ELECTRONIC STORAGE GRADING AND EROSION CONTROL PLAN GRADING DETAILS SHEET

EXTENDED DETENTION BASIN AS-BUILT
 DANE FRANK, TERRA NOVA ENGINEERING, 2024/10/30

ELECTRONIC STORAGE
 PROPOSED DRAINAGE MAP
 PROPOSED DRAINAGE MAP

COUNTY PRJ #: PPR-20-020
 EPC 11/29/21

OUTLET ORIFICE PLATE NOT TO SCALE

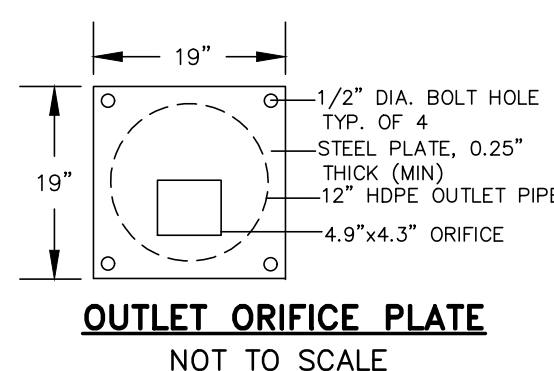
This is not acceptable as an "or equivalent" alternative. The intent of the trash rack in front of the orifice plate is for the openings in the trash rack to be less than the orifice holes. That way debris that is large enough to clog the orifice plate cannot pass through the trash rack.
 DCMv2 Chap 4.2: "Provide a trash rack of sufficient size to prevent clogging of the primary water quality outlet."
 MHFD DCMv3 states: Eliminating well screen [is acceptable] if orifices are large enough to be protected by standard bar grating. Orifice dimensions greater than 1.25 inches are generally large enough to eliminate the well screen in favor of standard bar grating. Do not eliminate the well screen if the smallest orifice dimension is less than 1.25 inches.

OUTLET STRUCTURE NOT TO SCALE

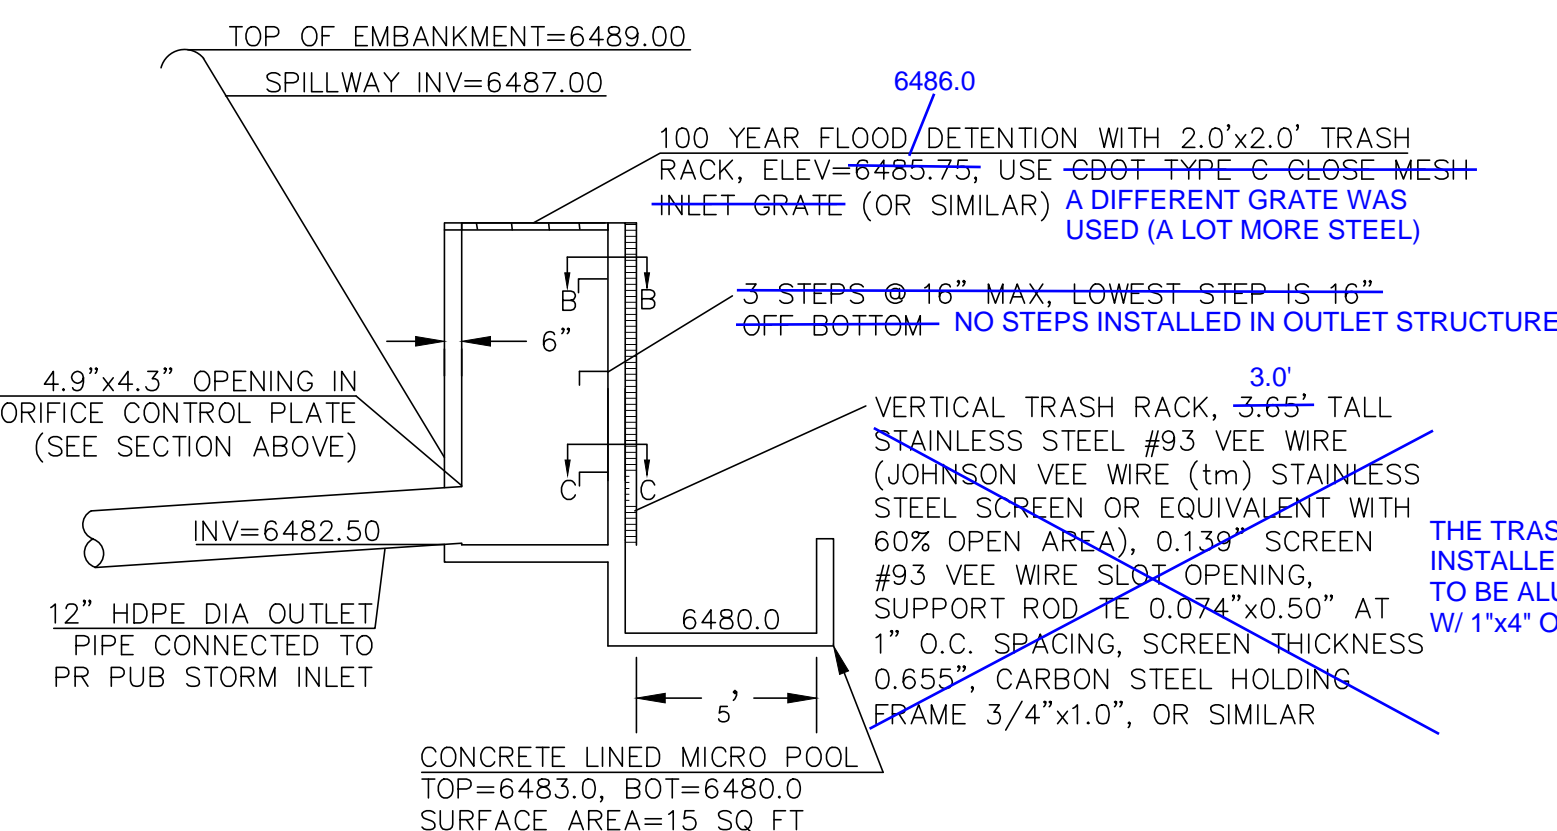
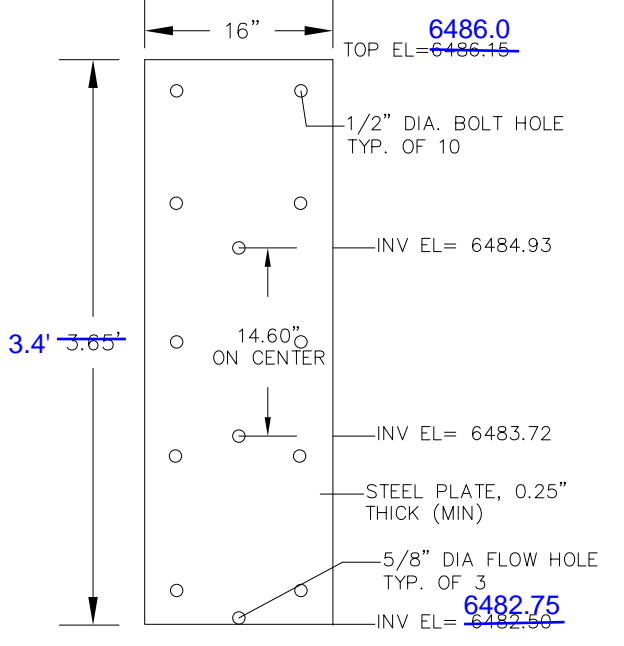
Access must be provided to the outlet structure (via steps per DCMv2 Chap 4.2: "Access to critical elements of the pond (inlet, outlet, spillway, and sediment collection areas) must be provided." And: Either a ladder or steps shall be installed when manhole depth exceeds 30 inches (see ECM Storm Sewer Manhole Detail SD_3-2).
 This is a general safety concern for if someone ends up in the outlet structure, there must be a way for them to exit. And it allows for removing sediment and debris from the outlet structure.

EDB EMERGENCY WEIR NOT TO SCALE

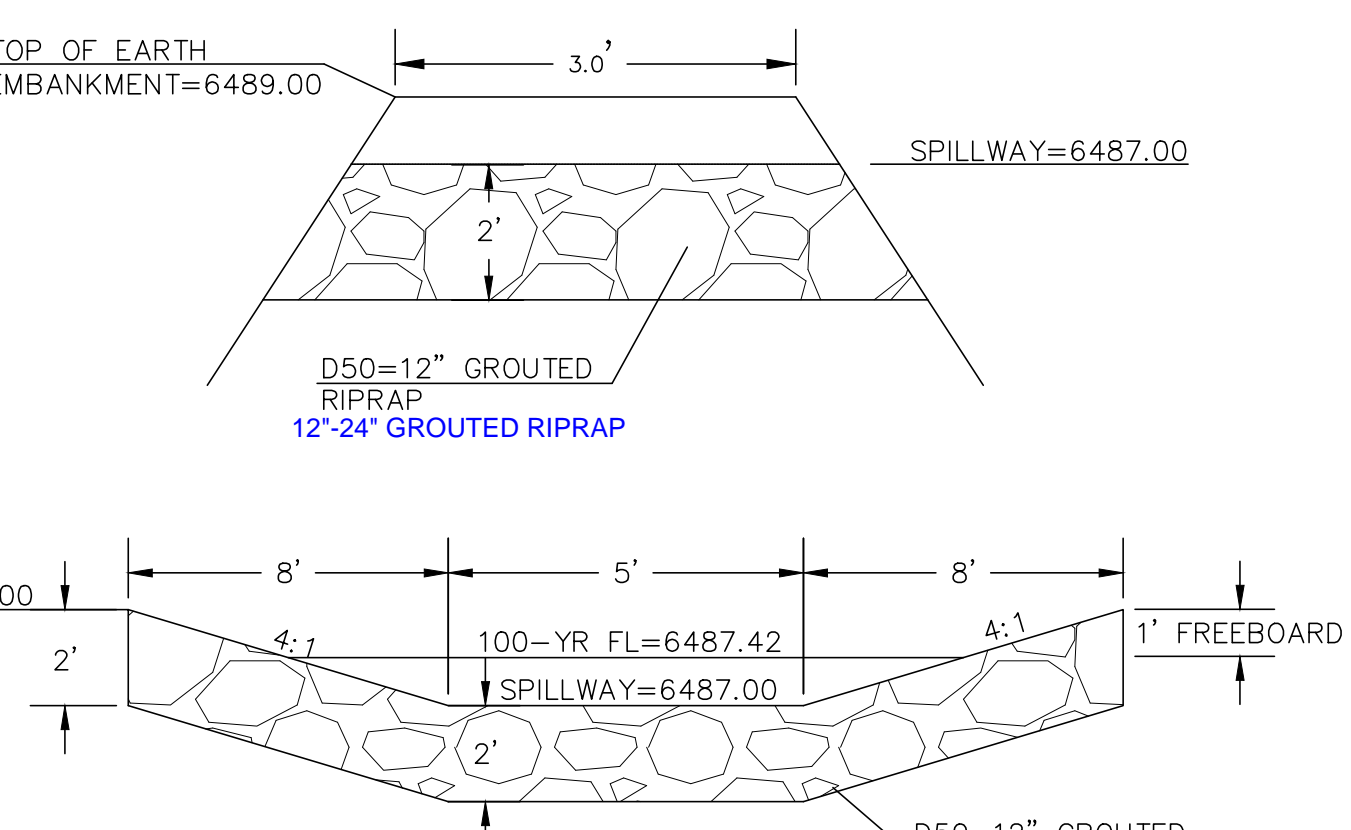
It is not ideal to have the spillway flows concentrated immediately downstream of the grouted spillway. You will need to re-run calcs to show that the riprap installed can withstand the increased velocities from the narrowed conveyance. Or remove this riprap and allow flows to follow the pre-existing contours shown on these original plans.
 Also, as shown in Photo 5 in the SW PA Punchlist, the riprap is placed on top of the grouted spillway. This riprap will badly erode on either side of this riprap instead of being conveyed through it as intended like a swale.

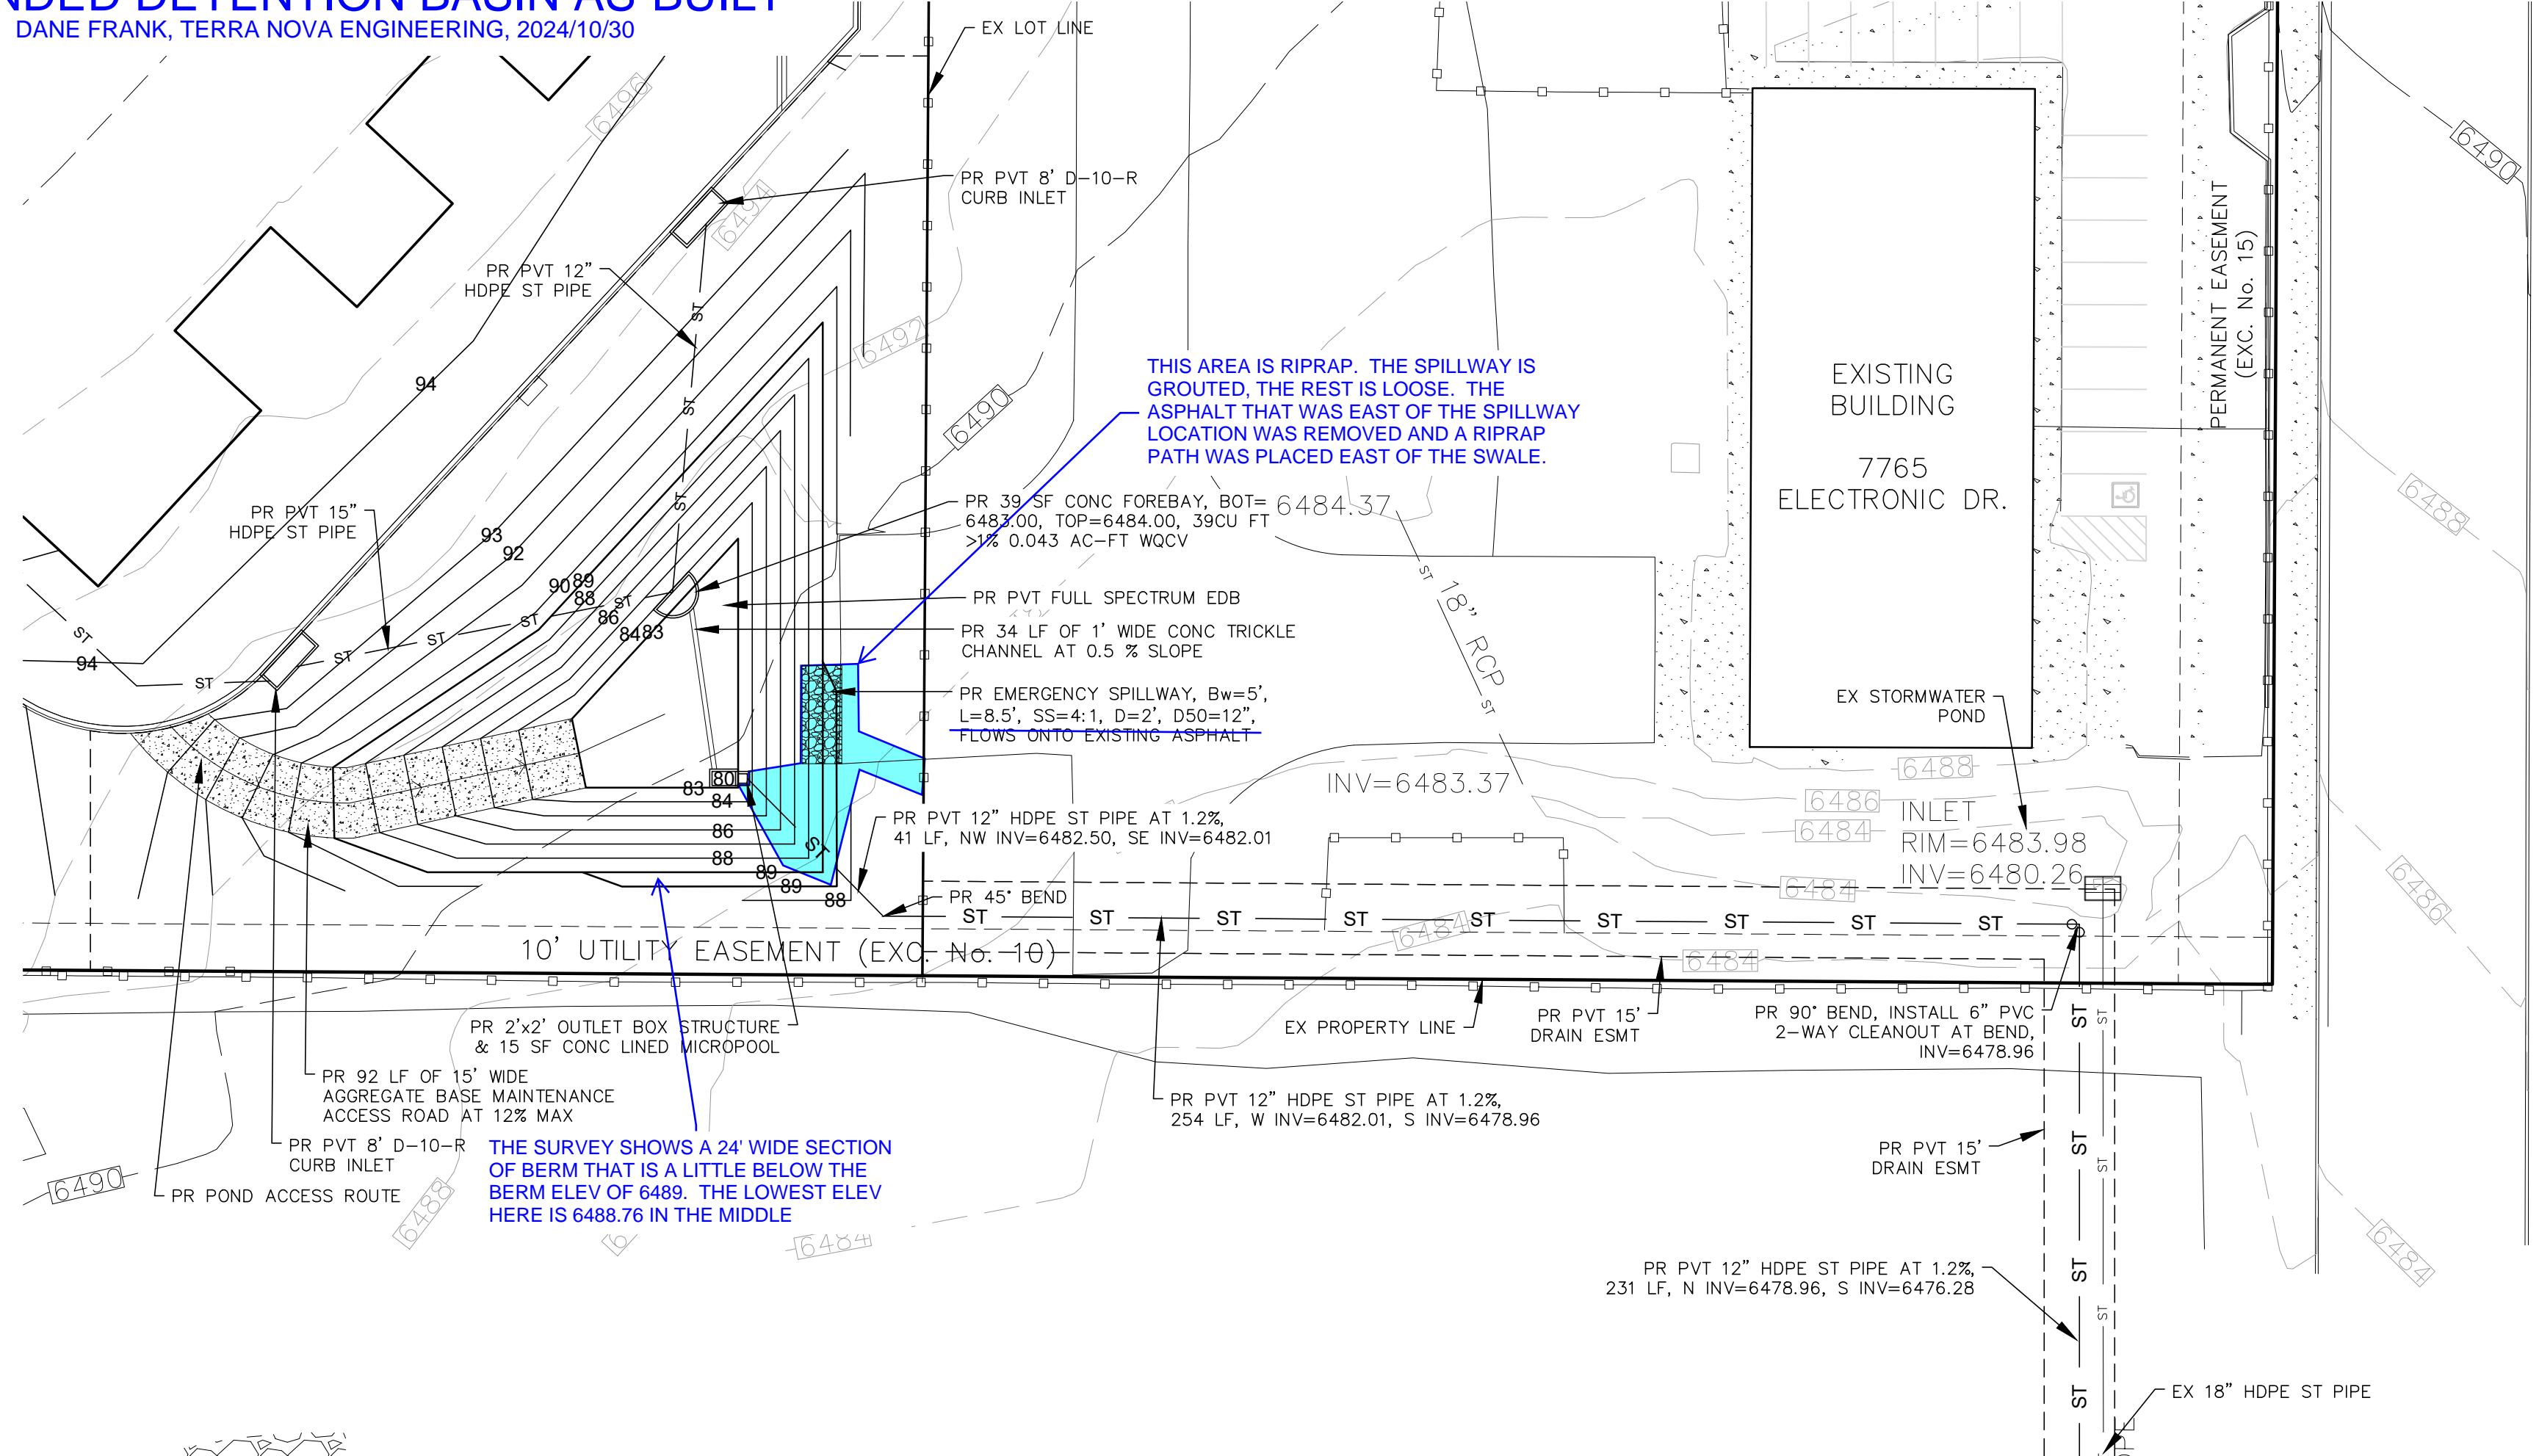
Include As-built condition stamp and EOR signature on each sheet. Per ECM 5.10.6 Engineering Record Drawings: Each sheet of the record drawings shall be designated as "Engineering Record Drawings" and signed and dated by the engineer of record.
 Even if everything was built exactly per plan, we need an electronic PDF of the original drawings to be signed, dated, and stamped with "As-Built" on each sheet.
